**From:** Joe Vertel <J.Vertel@mosman.nsw.gov.au>  
**Sent:** Friday, 27 July 2018 4:47 PM  
**To:** Tim Green  
**Subject:** SSD 7419 - Modifiaction to the Australian Habitat and Wildlife Retreat

Figure 4 | The approved (left) and proposed (right) roof of the Taronga Centre illustrating the solar panels
(Source: Cox Architecture)

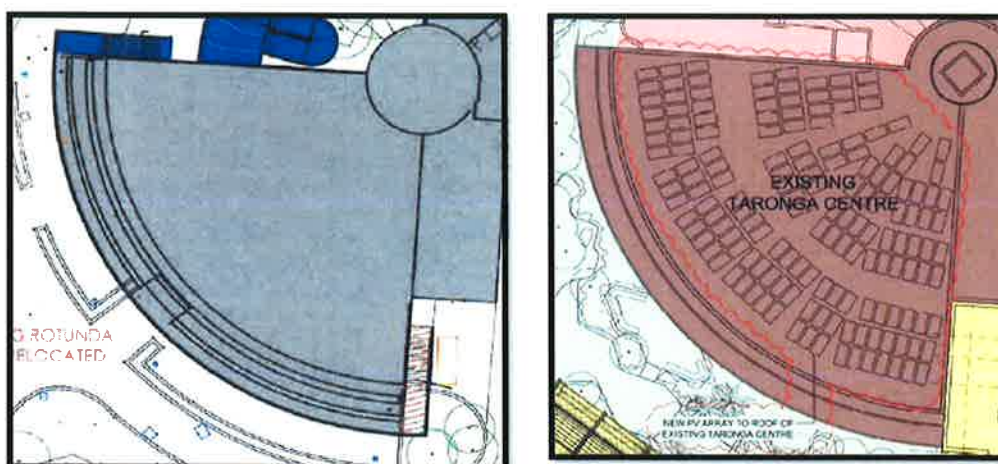
Council recommends that any changes to the buildings, specifically the provision of the shroud to the skylight and provision of photo voltaic panels should be designed and sited to ensure a minimal visual impact when viewed from surrounding headlands, residential properties and the harbour.
